Attachment B - Response to the Government Architect's Office Response

Drawn By	Date	Purpose	Approved By	Date
CHS	15/04/14	SPW	JP	
SCALE 1:100 @ B1	1:250 @ A3			
Site No.	Drawing No.			Revision
BR8	BR8AD4500002-05

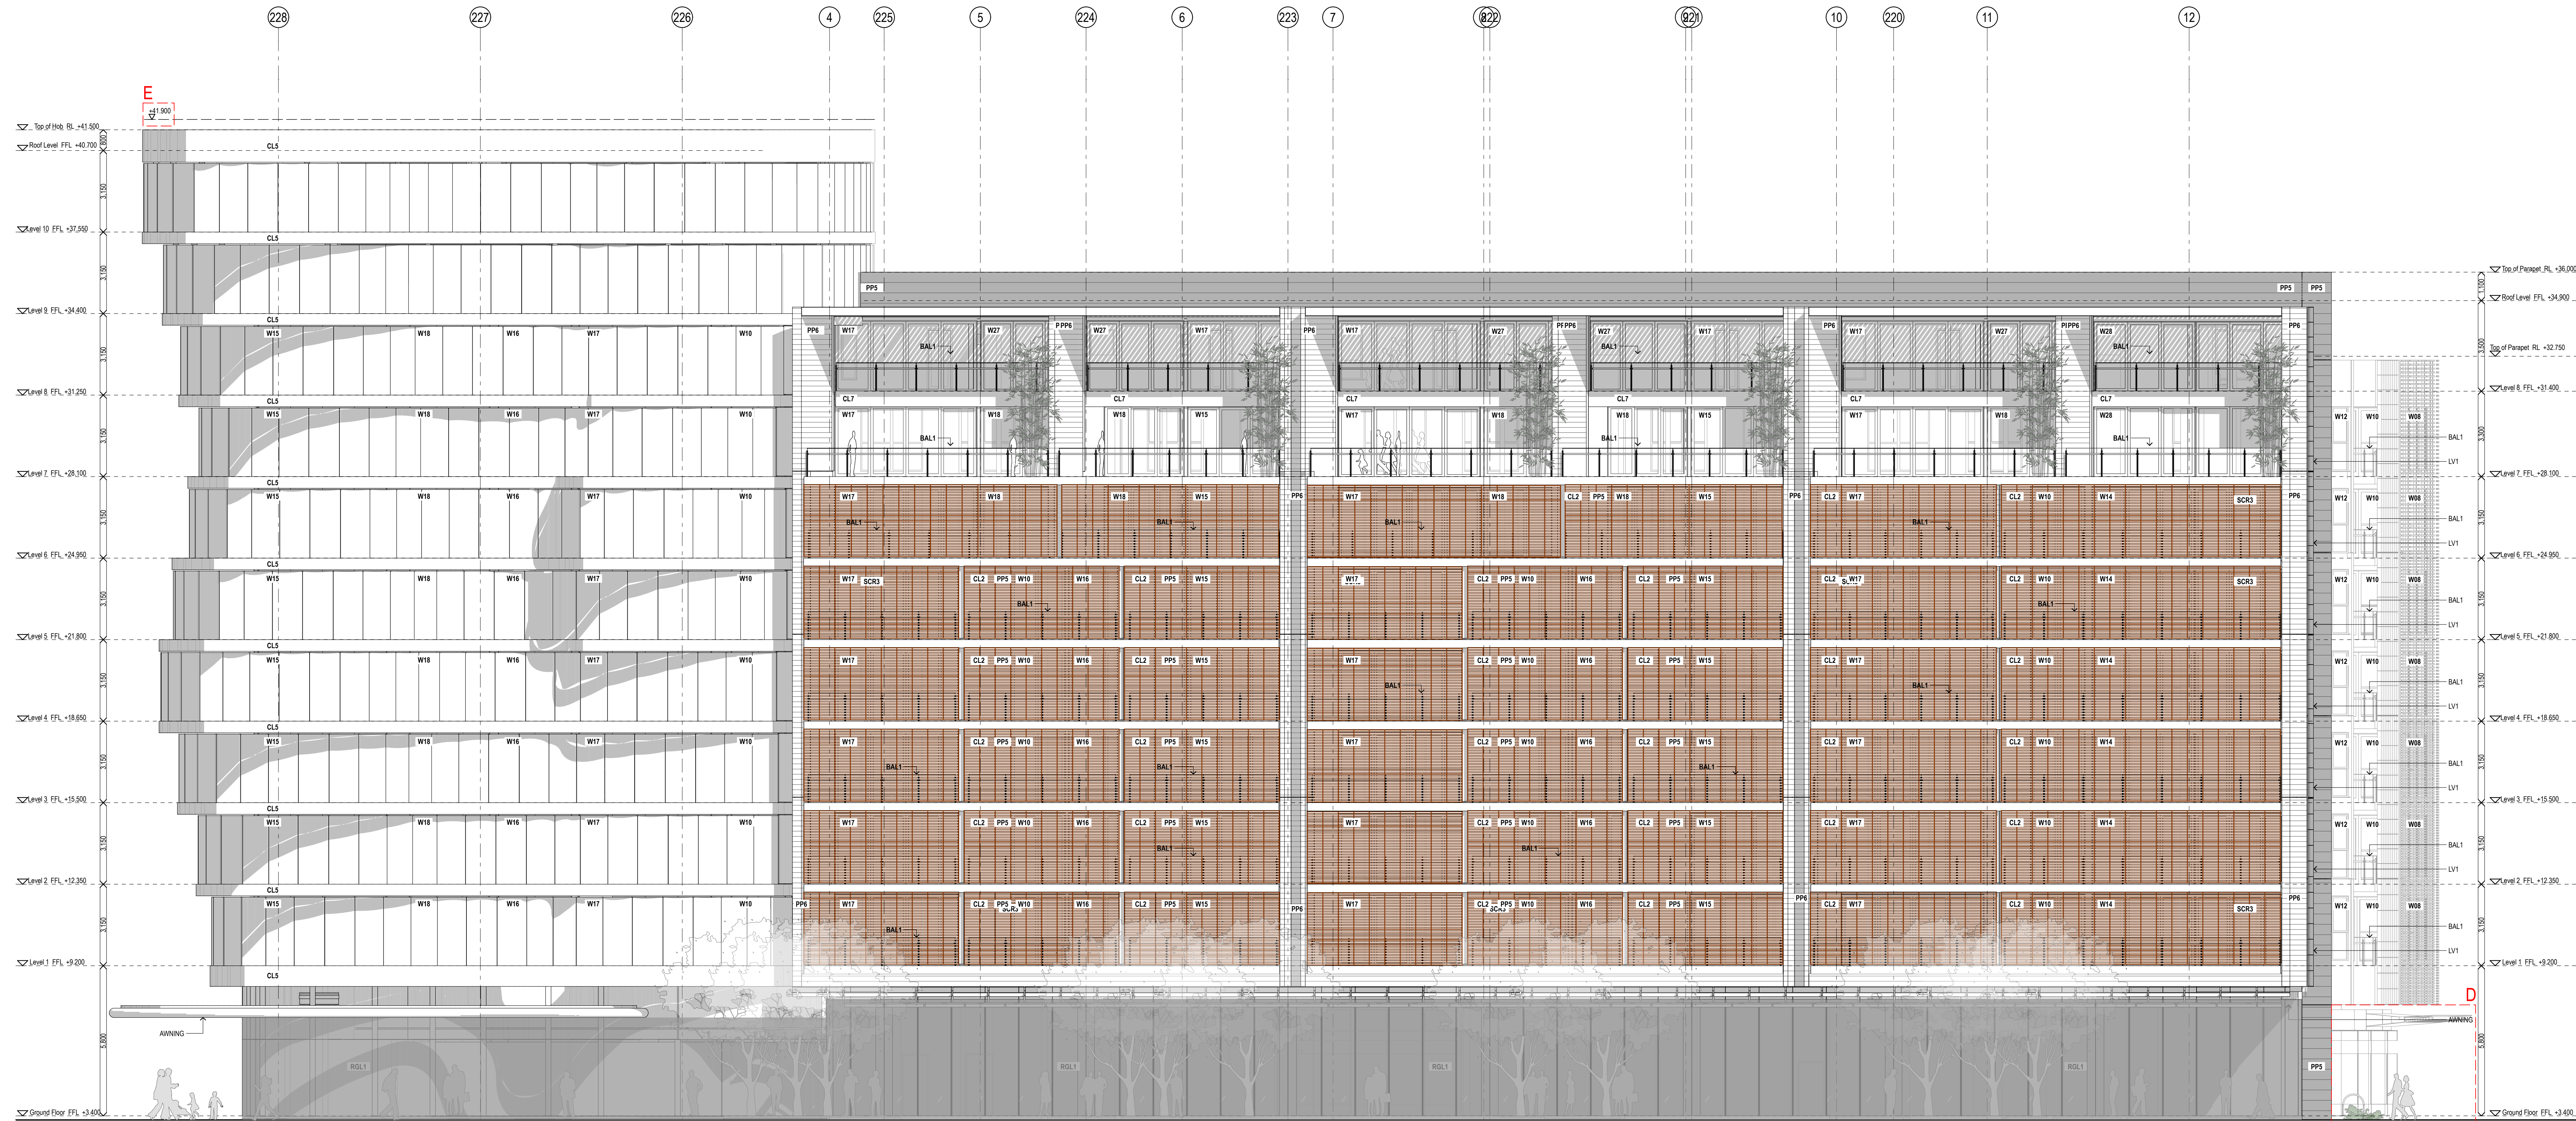
| Government Architect's Office Comment | Applicant Response |
|---|--|
| New en-suite windows are noted on AD4500002-06 (level 8), but are not shown in elevation to all levels as reported in the JBA report (table 1). | The note on the elevation was in the wrong location and has been adjusted and included in the revised drawing set. |

1 Typical Retail Facade Option A_Fixed Glazing
1 : 50

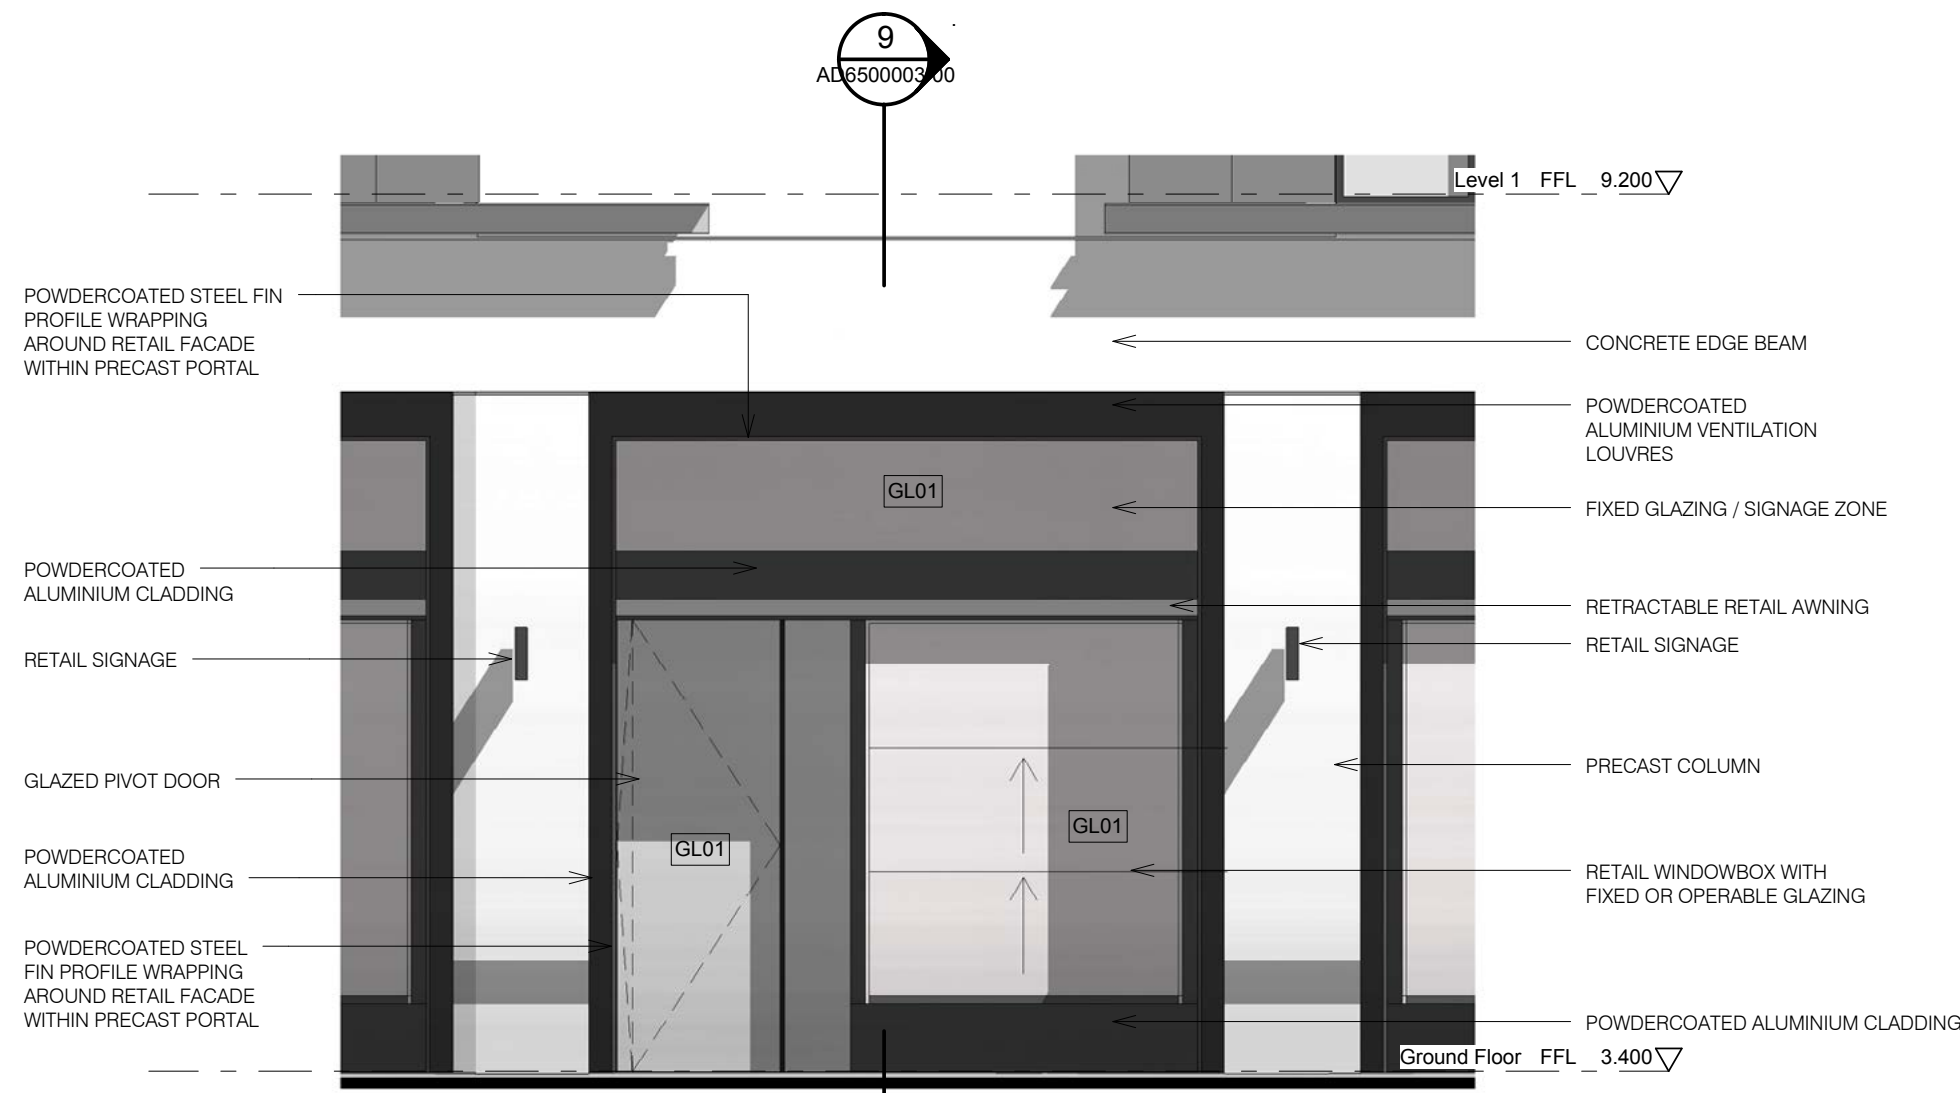
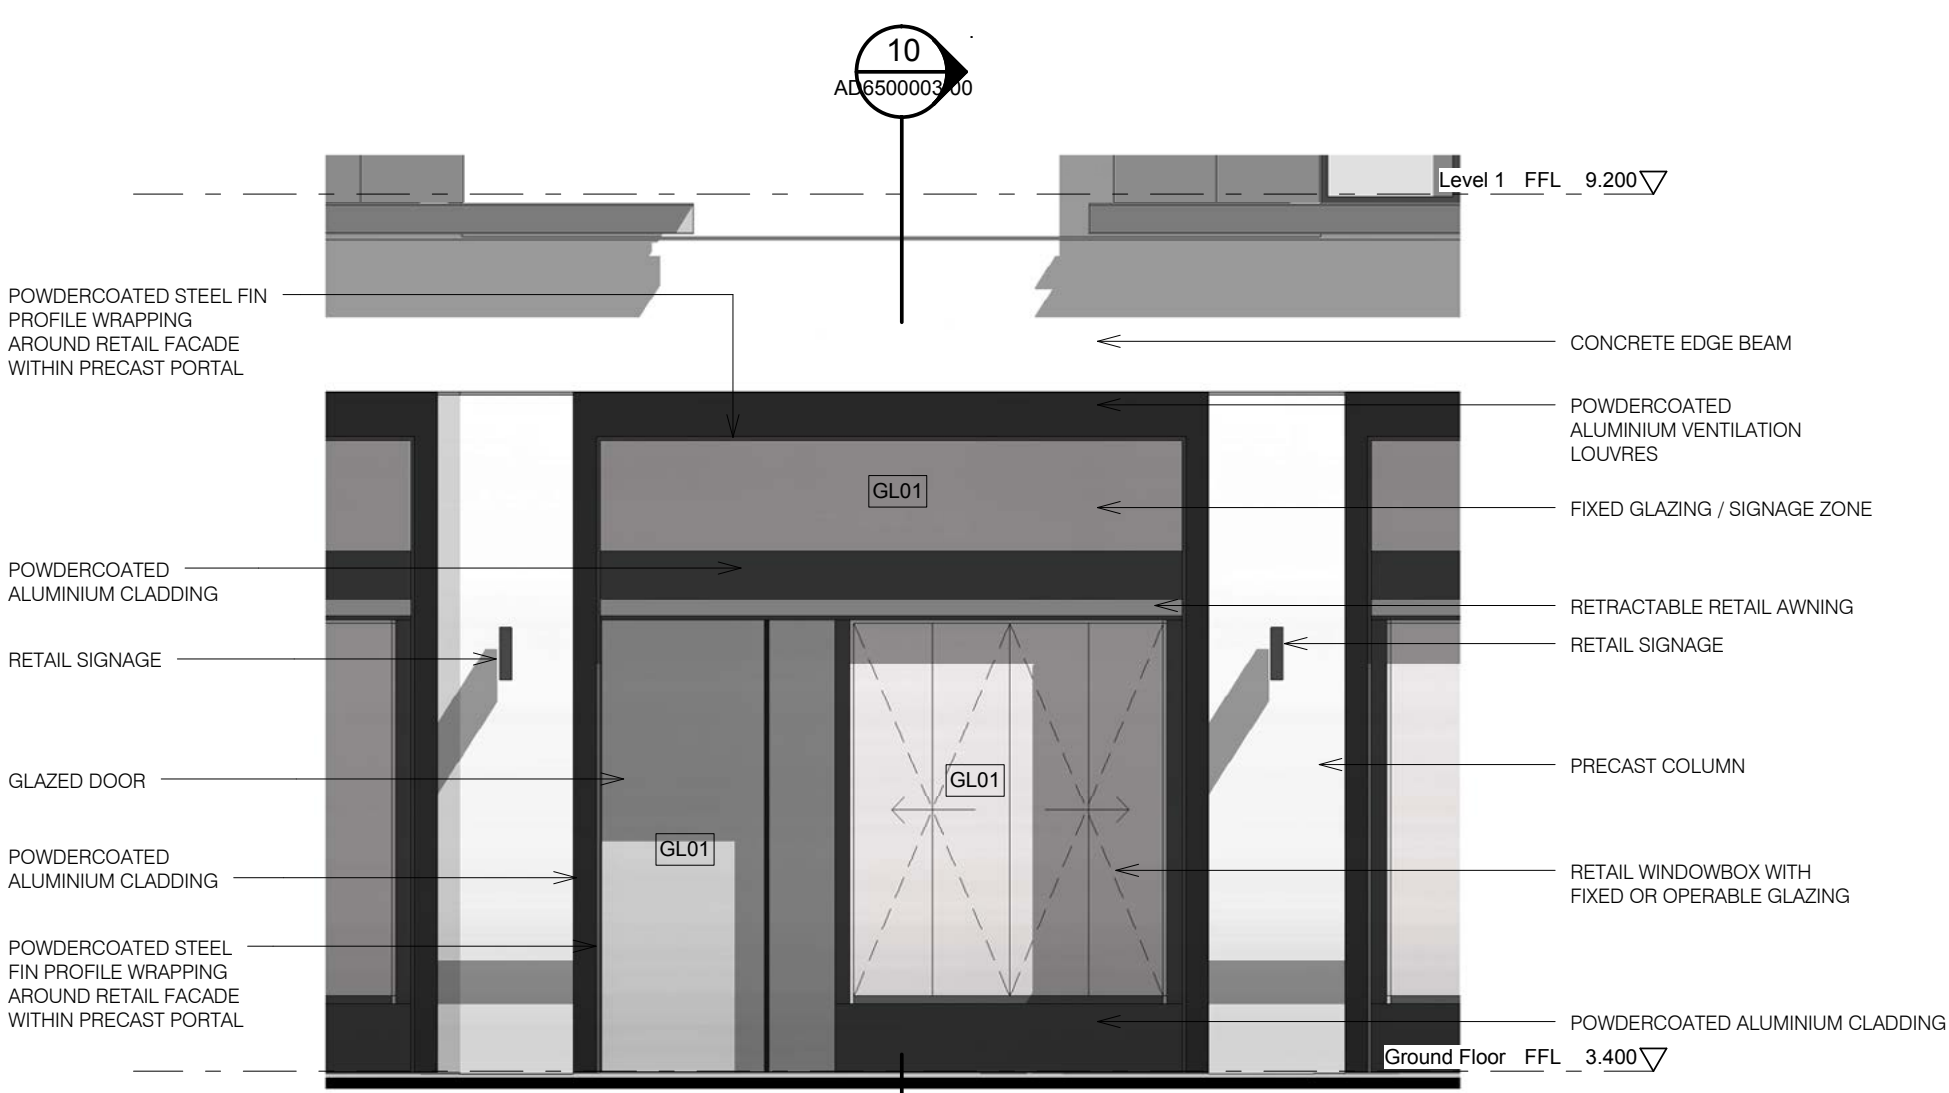
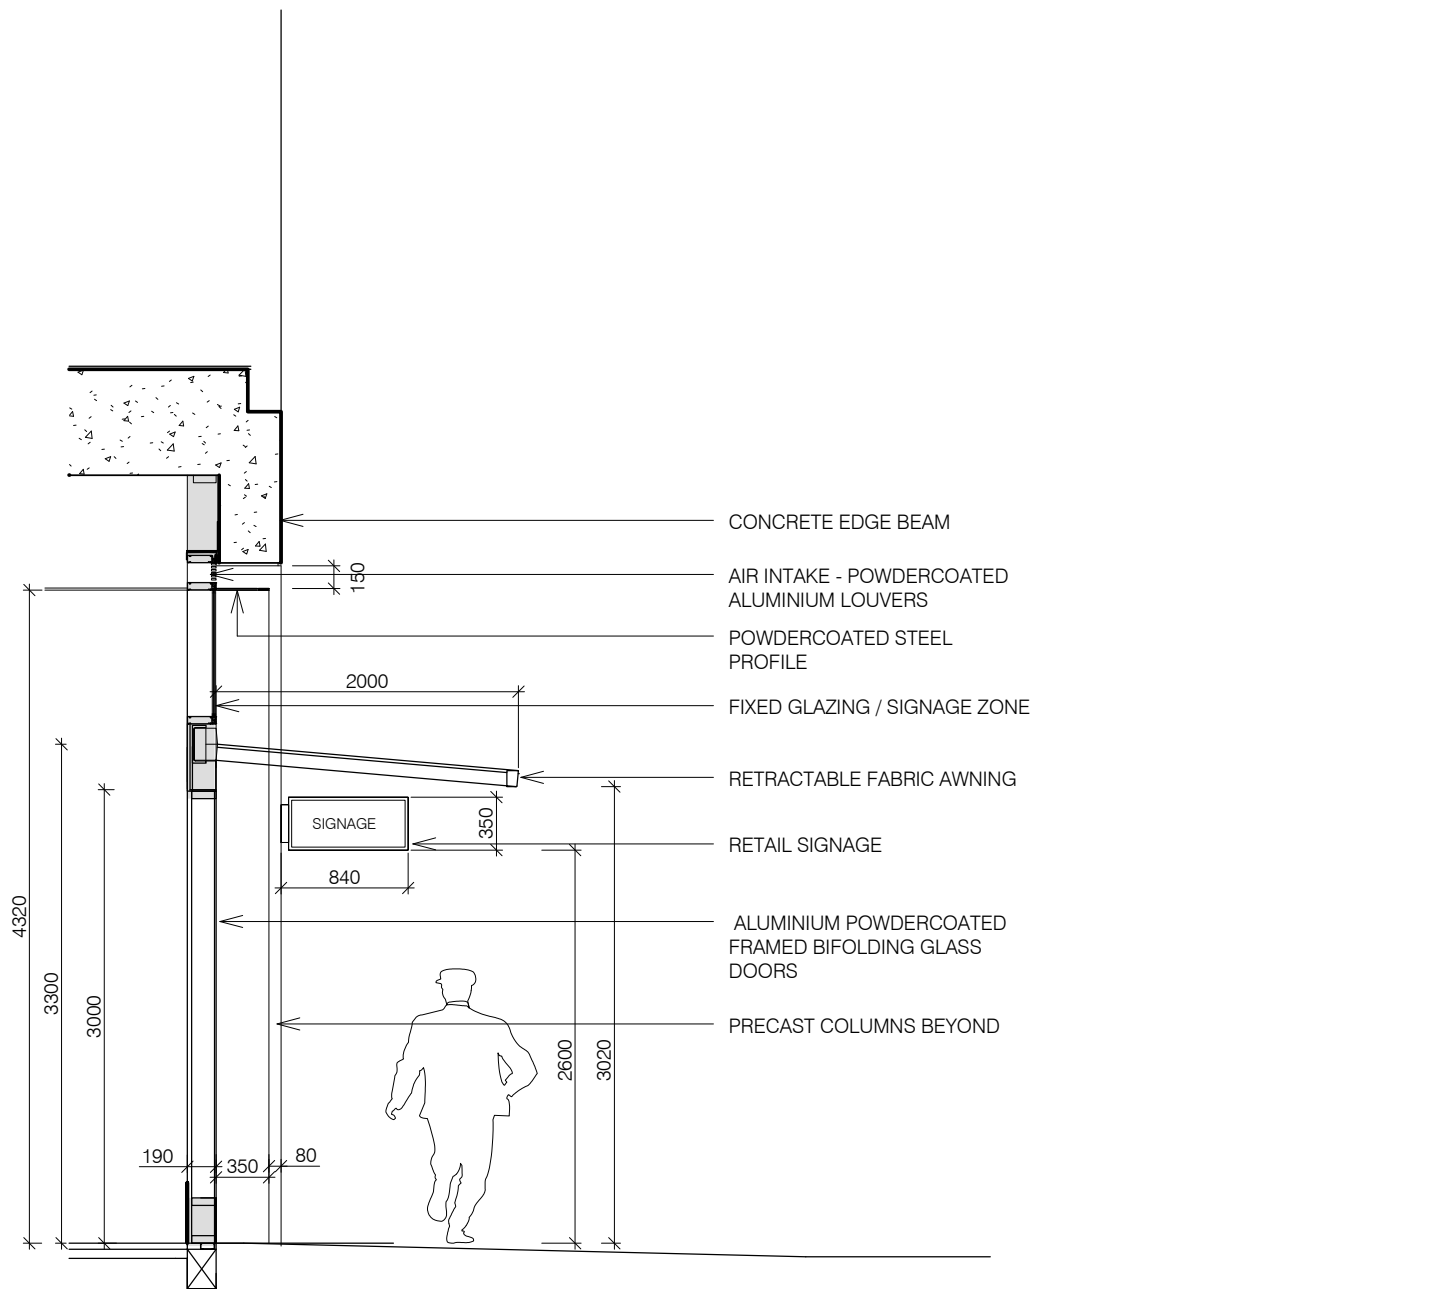
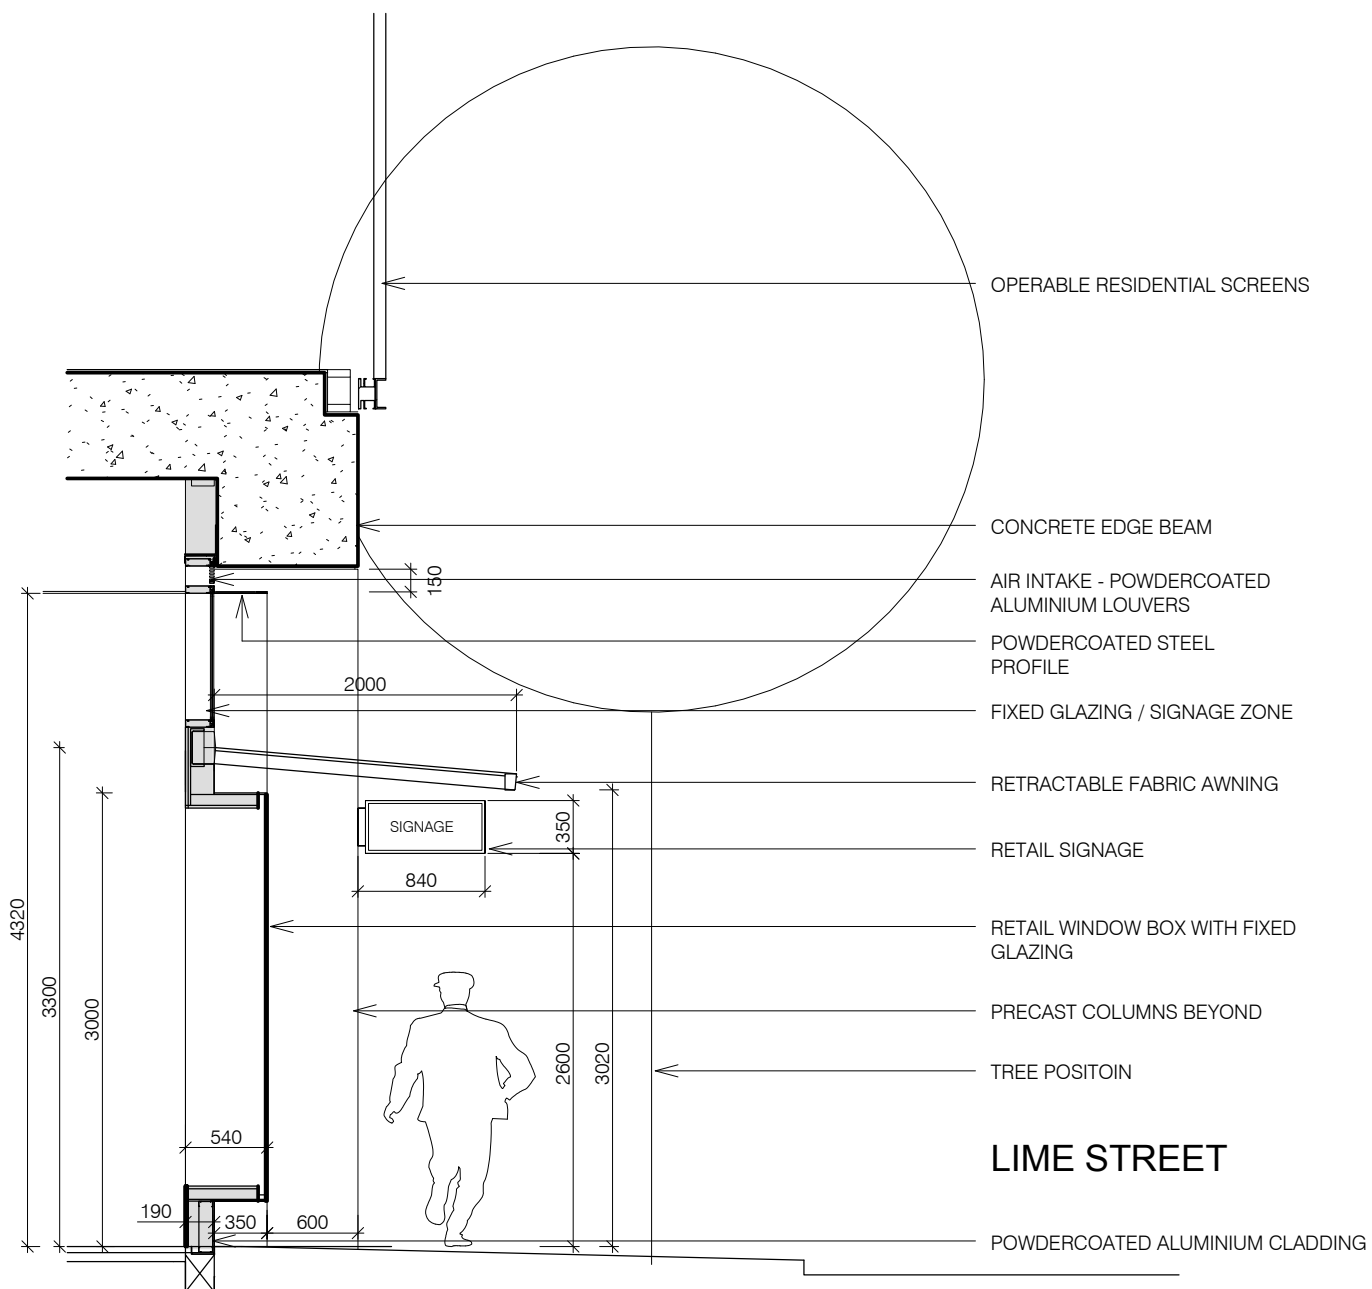
| Government Architect's Office Comment | Applicant Response |
|---|---|
| <p>The overall design intent for the shop fronts to Lime Street, including the method for the selection of shopfront types (R9) is not clear. Four options are provided for R9. As above, a minimum or maximum number of shop front types to be used would clarify the design intent on this elevation.</p> | <p>See response above.</p> |
